April 30, 2019

**SUBJECT: Monument Academy Site Development Plan
Response to NEPCO Comments
PPR-19-009**

C1.1

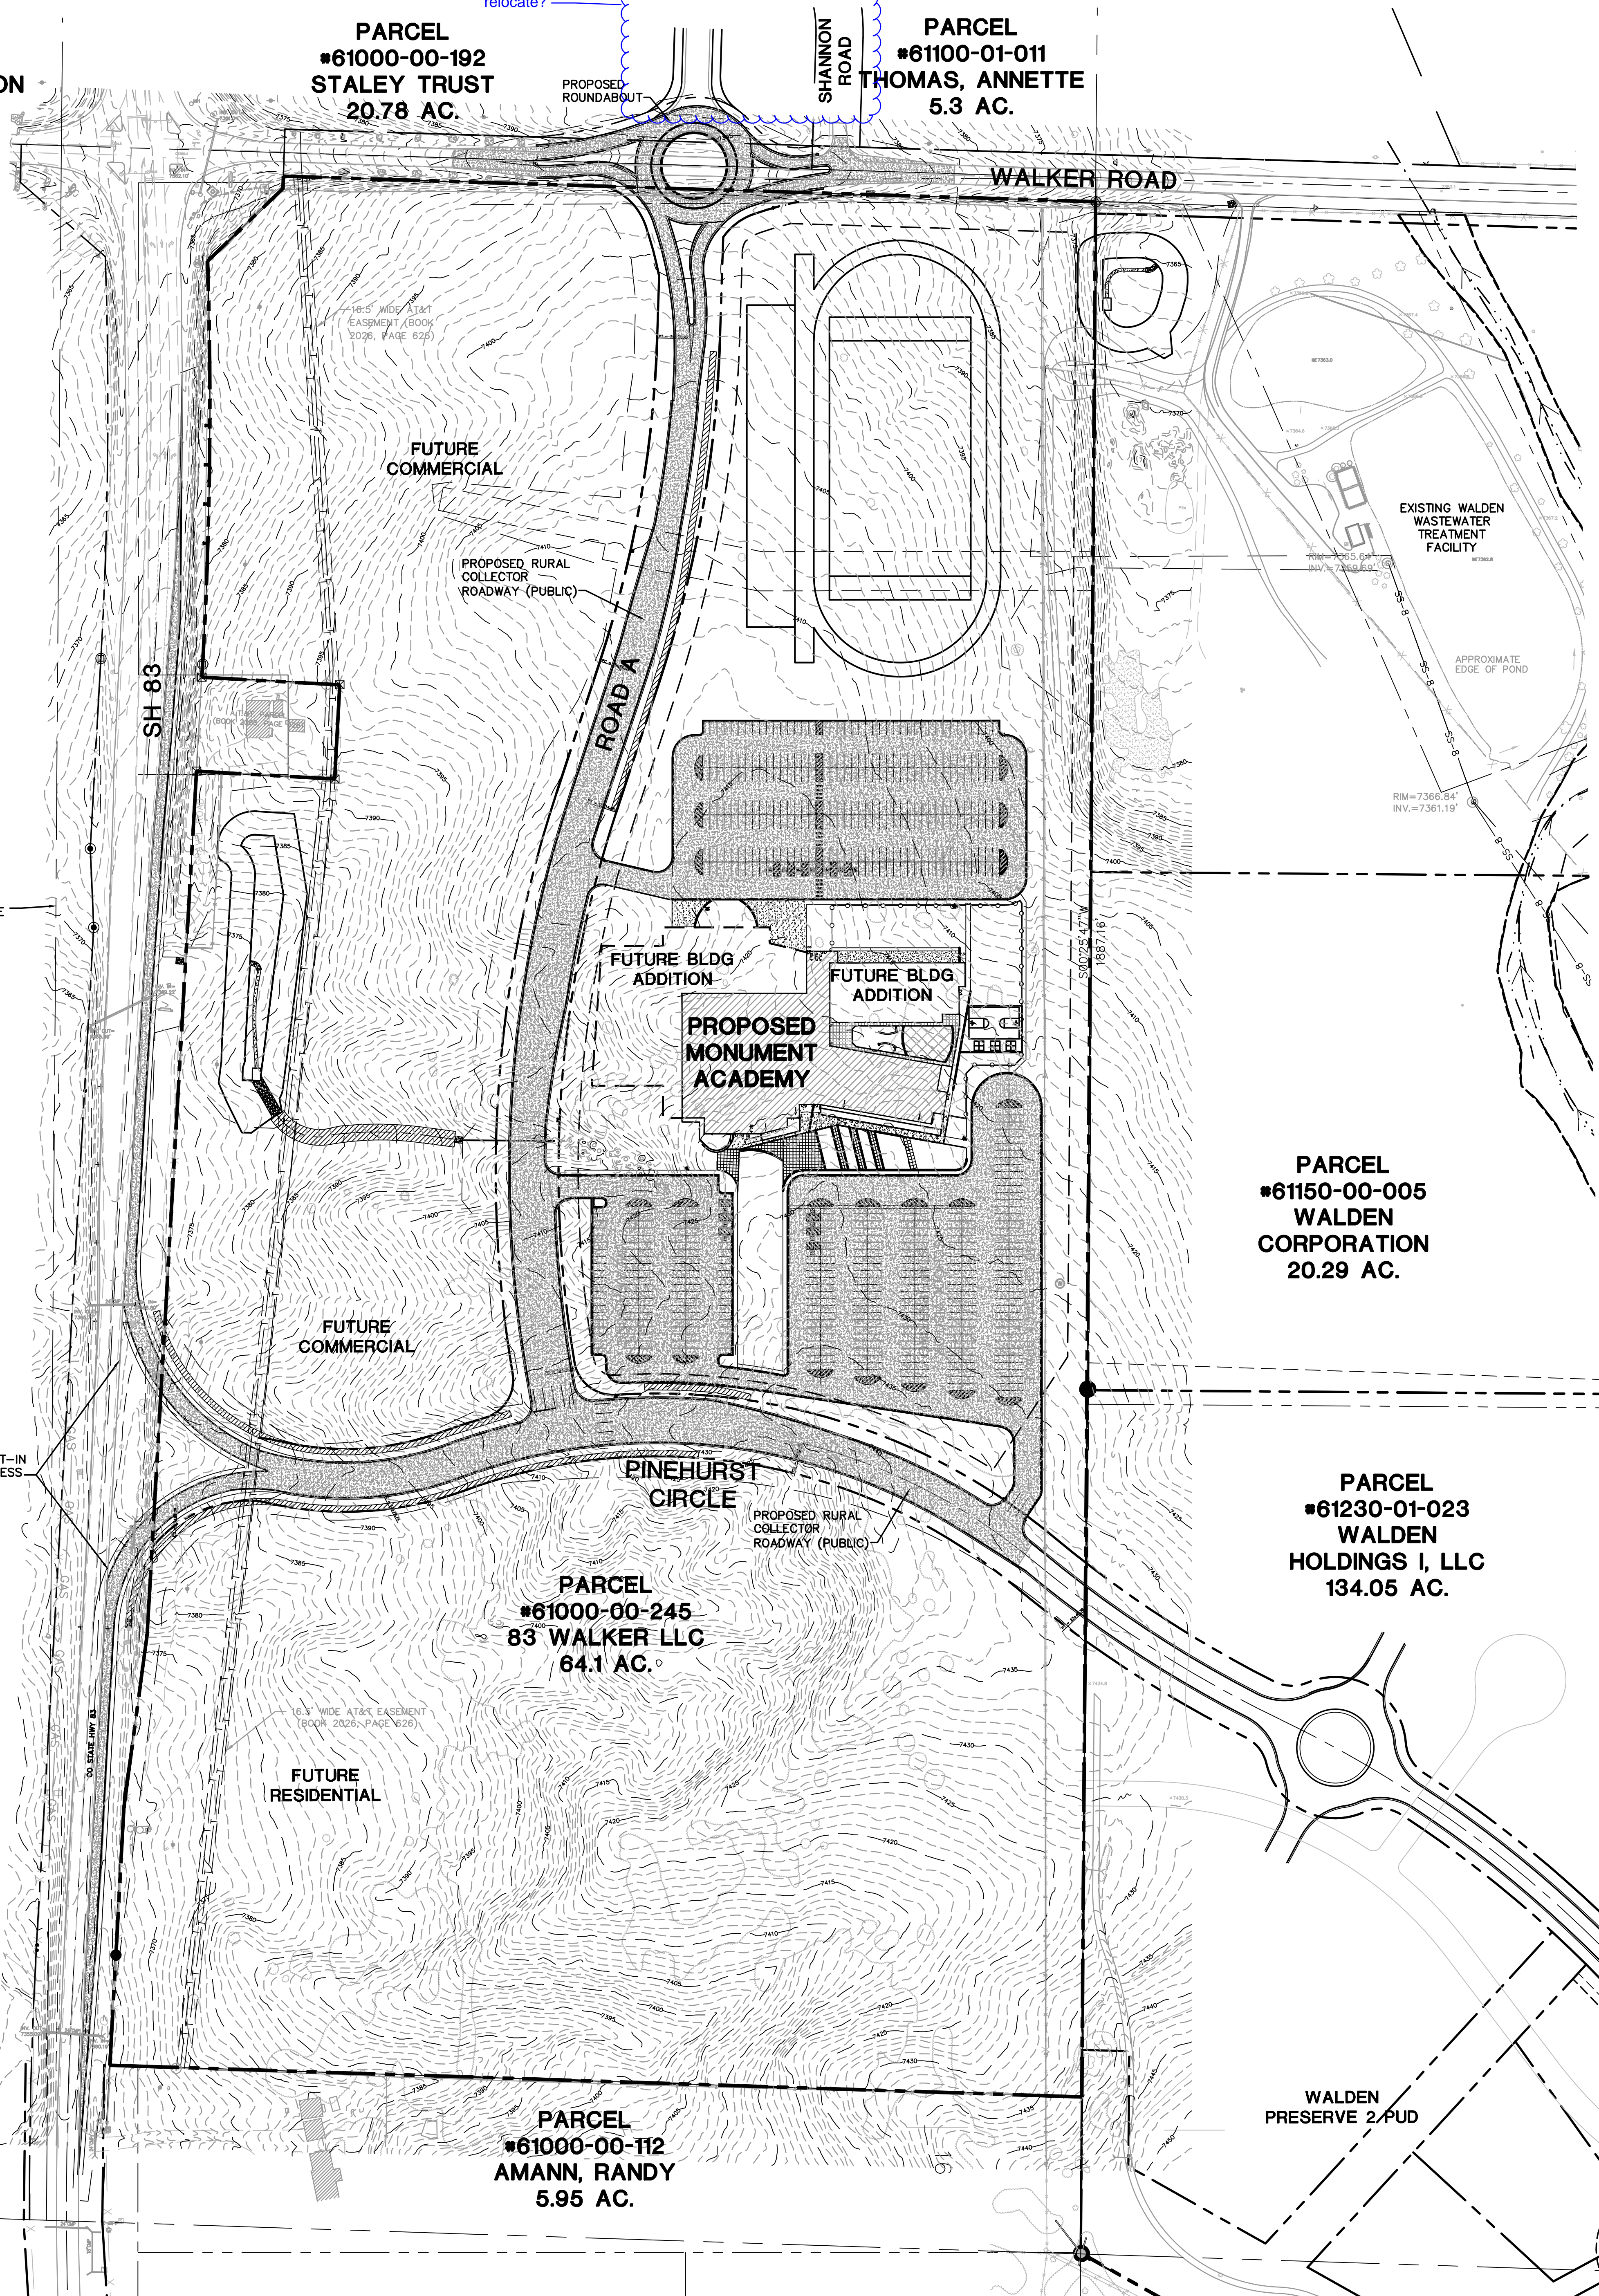
- b. **Construction Drawings**, Page 2: Only about half the lot appears to be involved in the school development, while the other half is called "future commercial." Is this lot being subdivided? Does approval for the school make a re-zone to future commercial (or residential—see below) a done deal? **(While sound engineering practice dictates consideration of potential future development patterns, this application is limited to the Site Development Plan for the school site, and any future development will need to go through the standard County Planning review process.)**
